Panorama Battery Energy Storage System (SSD-50587460) – Transport for NSW Request for Further Information

SSD-50587460 – Panorama BESS, TfNSW advice on Response to Submissions and Amendment Report

SSD-50587460 – Panorama BESS, TfNSW Advice on Amendment Report, Bathurst Local Government Area

RIGHT TURN
Lachlan Valley Way &
Mid Western Hwy

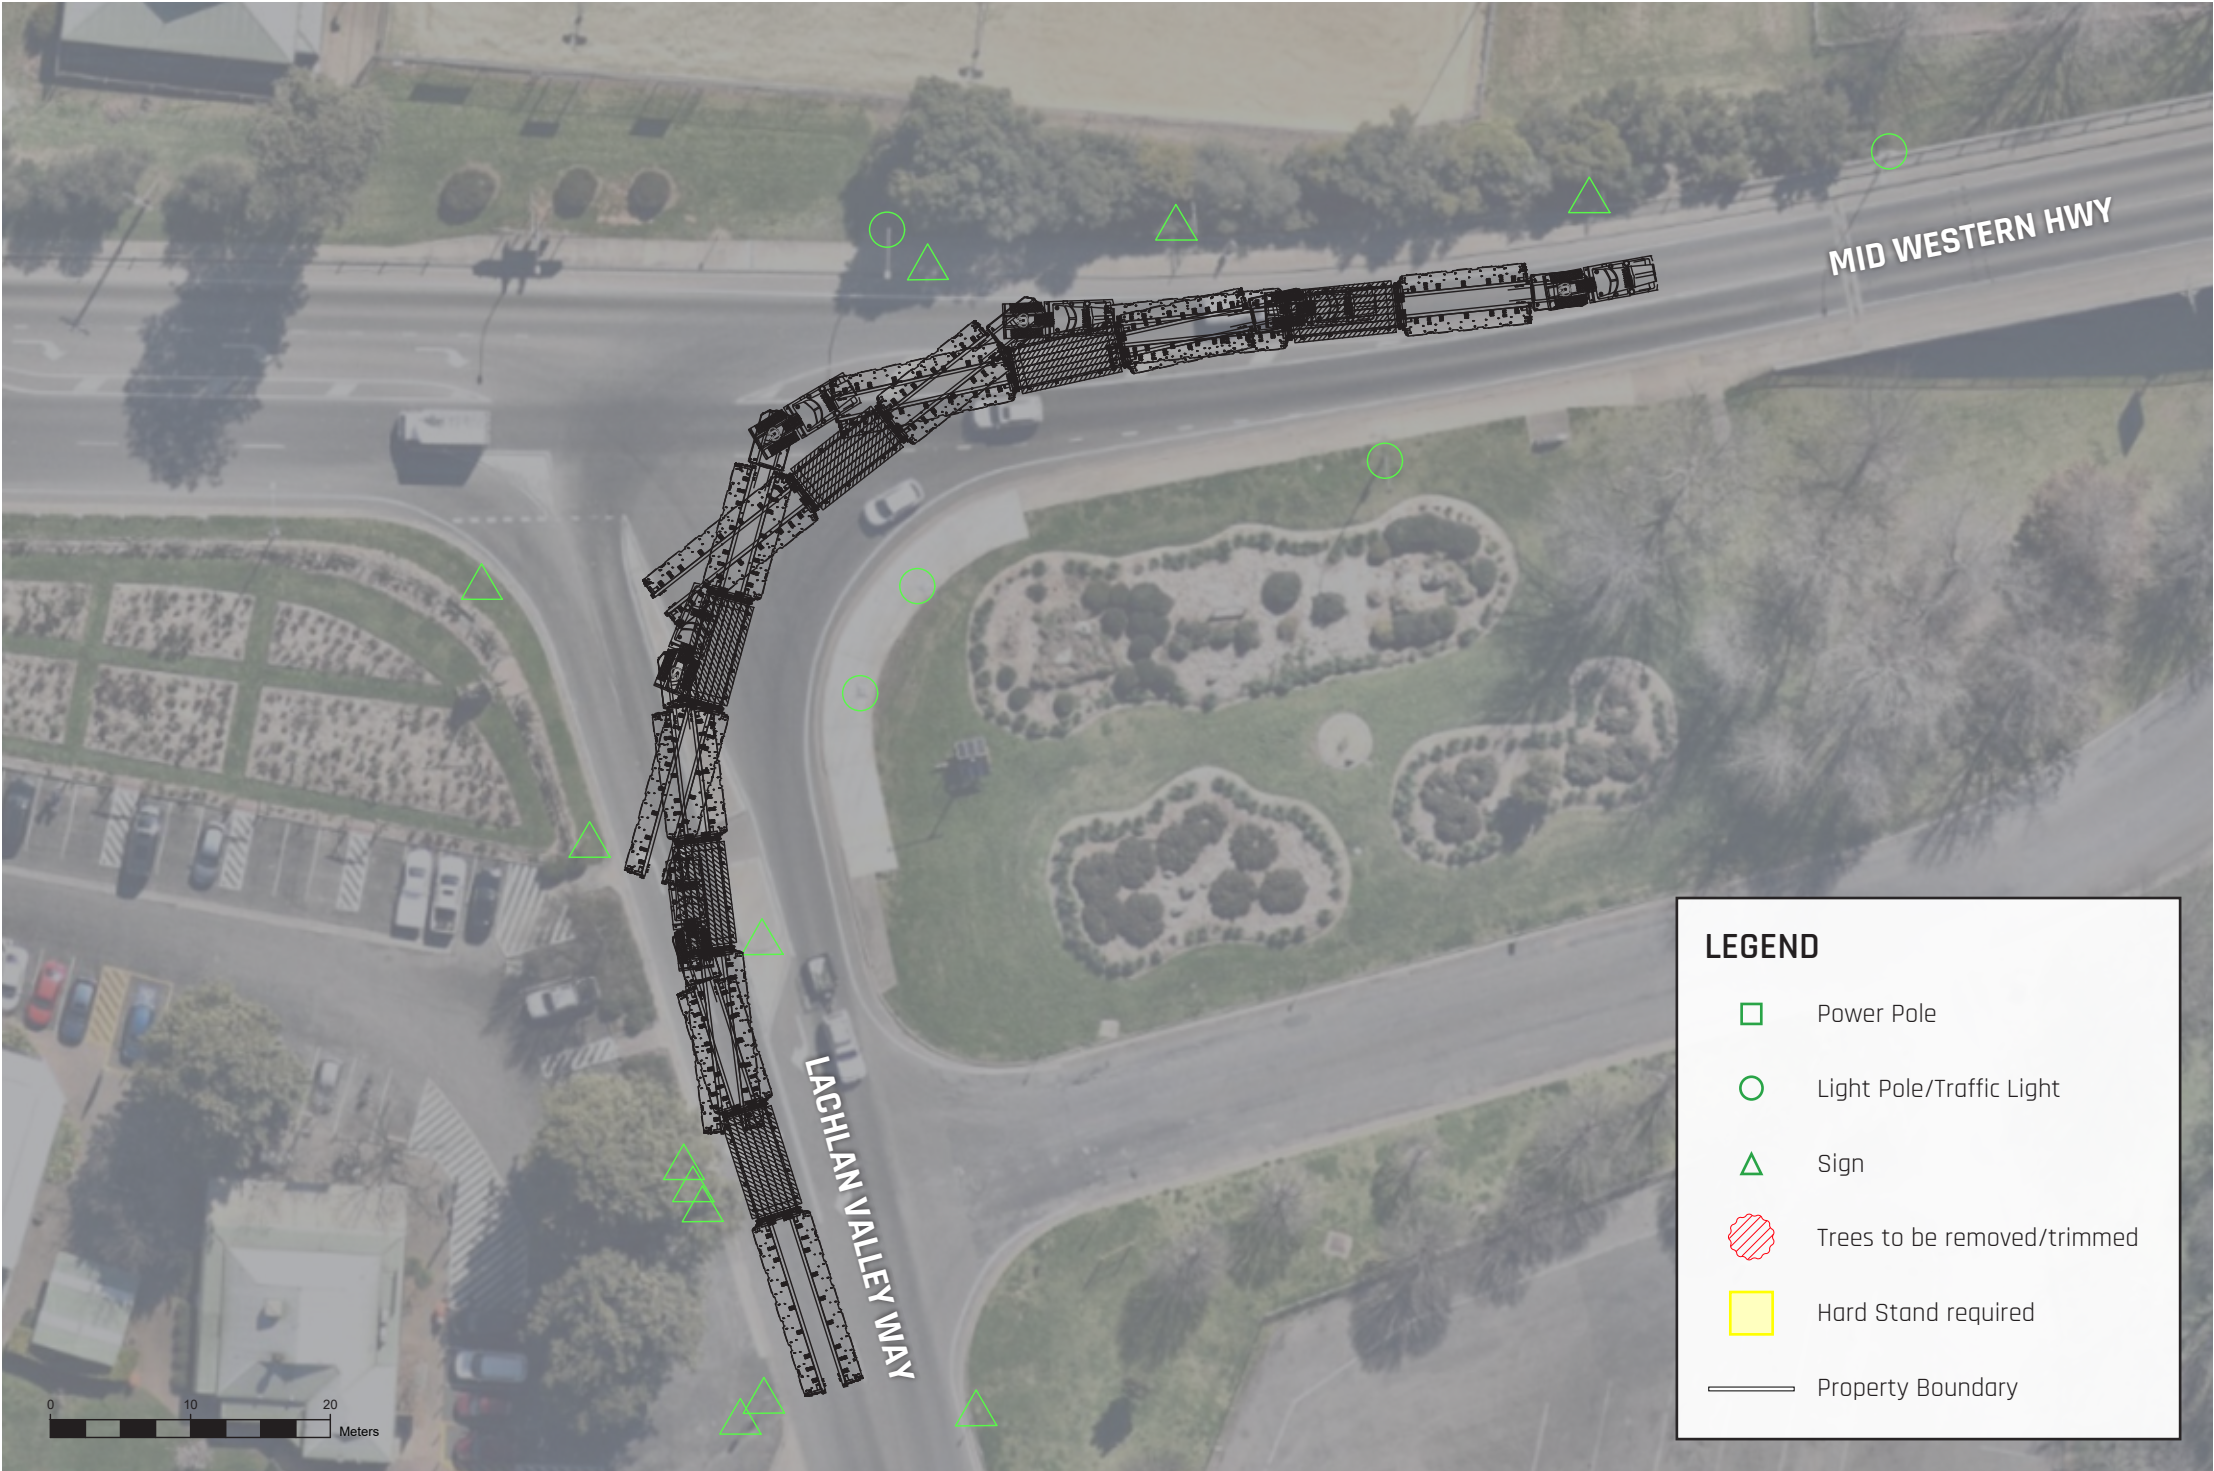
-Roundabout on Lachlan Valley Way is shown to be impacted by the vehicle swept path as well as the medians either side of the roundabout at the locations of the sign removal. -The corner of Mid Western Highway and Lachlan Valley requires further investigation. If the existing pavement is not suitable, the proponent will need to provide strategic designs of the median that identify the scope of work required to strengthen the pavement of the median(s). Strategic concept designs are required for any identified works, see advisory notes.	The TIA (SLR, January 2026) includes the OSOM Route Study (Appendix D of the TIA). For the intersection at Lachlan Valley Way and Mid Western Highway, Cowra, TfNSW requested that as a precaution the central median should be removed and replaced as it is likely to be damaged during the OSOM movement. Recurrent Energy corresponded with Cowra Council who confirmed that this median is pinned to the road and therefore can not be easily removed and replaced. Council also identified that additional hardstand had been installed to the inner side of the turn which has been used by multiple wind projects. This provides an alternative to mounting the central median.

-Roundabout on Lachlan Valley Way is shown to be impacted by the vehicle swept path as well as the medians either side of the roundabout at the locations of the sign removal. -The corner of Mid Western Highway and Lachlan Valley requires further investigation. If the existing pavement is not suitable, the proponent will need to provide strategic designs of the median that identify the scope of work required to strengthen the pavement of the median(s). Strategic concept designs are required for any identified works, see advisory notes. <i>Note: core log samples will need to be taken as part of this investigation, which will require a s138 Roads Act approval and ROL.</i>

No.	TfNSW response in relation to RTS and request for information for revised TIA	Proponent Response
		Upon receipt of this information, TfNSW confirmed that the median can be left in place but should be transversed at the minimum extent possible. Since no road works are needed, no strategic designs were required for this intersection. <i>This RFI has been closed out. No further actions are required.</i>
